From: Bloomer, David <David.Bloomer@lancashire.gov.uk>
Sent: 23 July 2018 13:36
To: John Macholc
Cc: LHS Customer Service; planning
Subject: app3/2018/0236 Former Golf Driving Range, Lincoln Way

The above proposal is for the provision of a range of small industrial units on the site of a former golf driving range. The site has been subject of a previous application for a similar use . The previous application was for 10,486 sq m of office / B1 industrial floor space whilst the current application is for 4688 sq m.

SITE LAYOUT PLAN

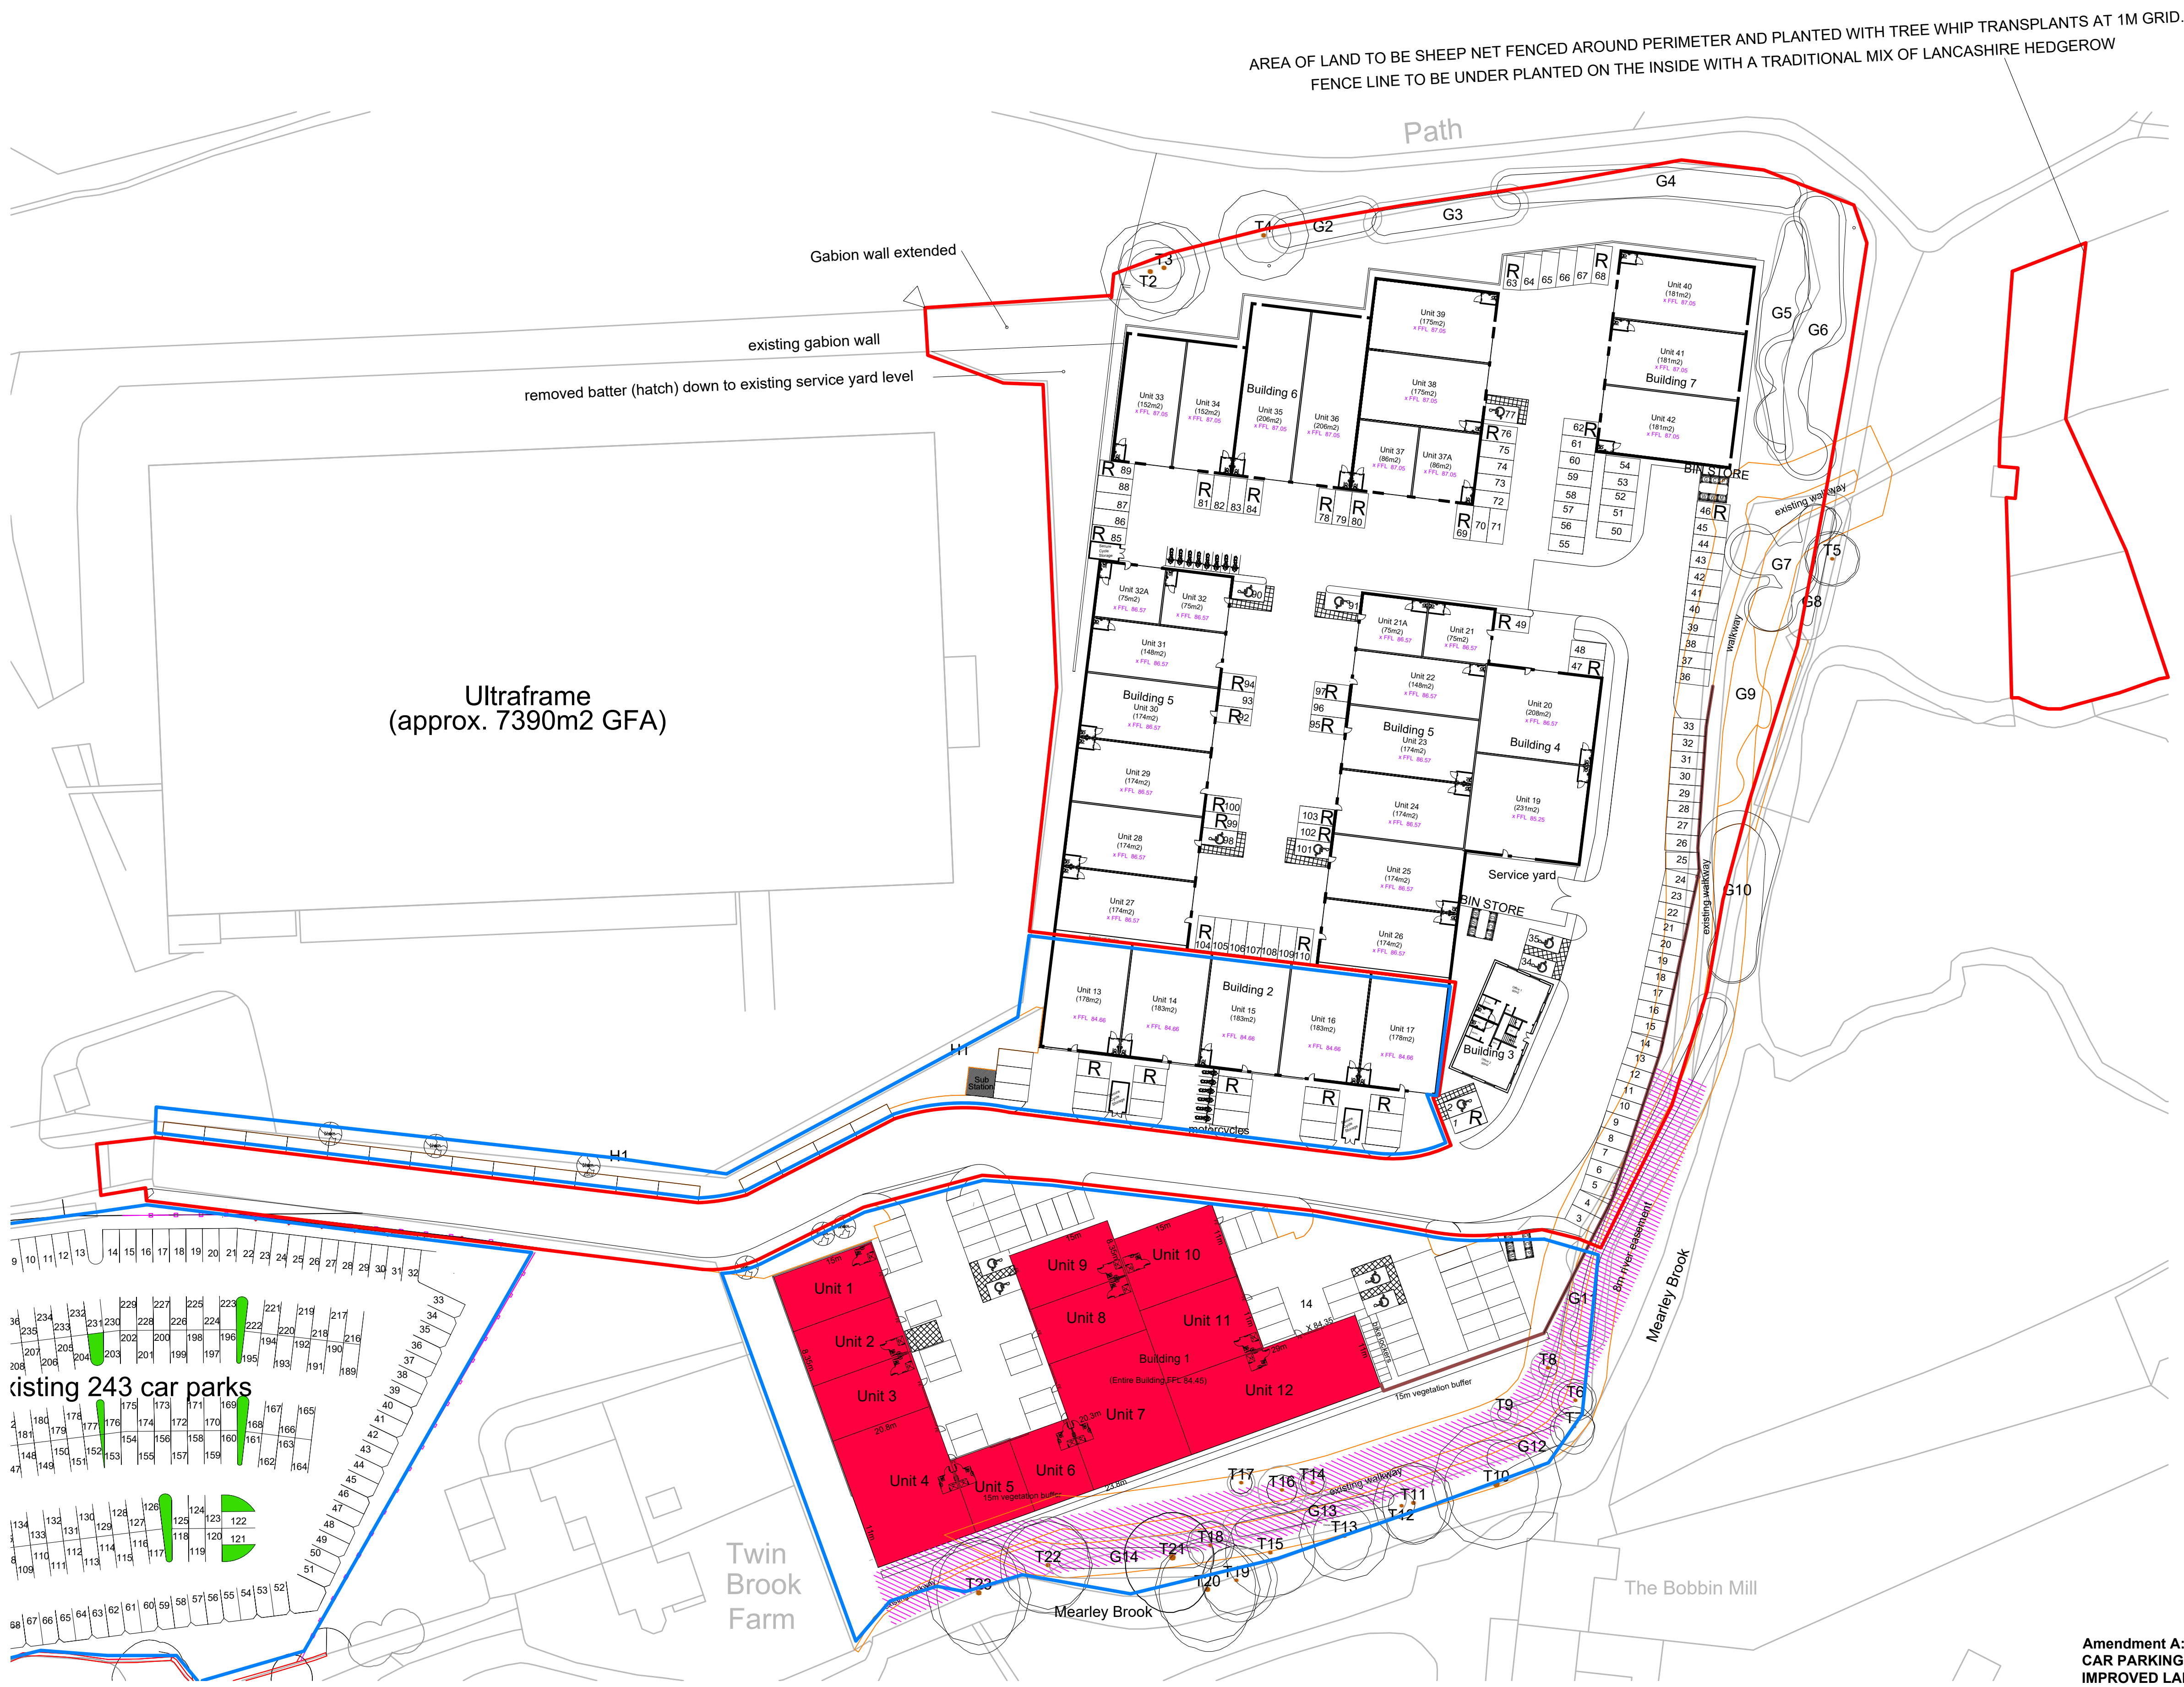
Notwithstanding the previous comments there are a number of changes to the proposed site layout that require further clarification

- i. Building 2 , comprising units 13 – 17 , is shown outside the red edge but dedicated parking is not shown for this unit. I have therefore discounted the 22 parking spaces fronting this building from the overall parking provision.
- ii. Seventeen parking spaces are shown along the northern side of the access road past the Ultraframe unit. These would appear to be provided at the expense of a continuous pedestrian route. As above theses 17 spaces should be removed from the overall parking provision.
- iii. Bearing in mind the 2 issues above the parking provision at 83 spaces is less than that which would be expected – 104 spaces
- iv. The m/cycle and cycle parking facilities , whilst welcomed are too close to the carriageway to allow safe manoeuvring in / out of the spaces and should therefore be set further away from the carriageway
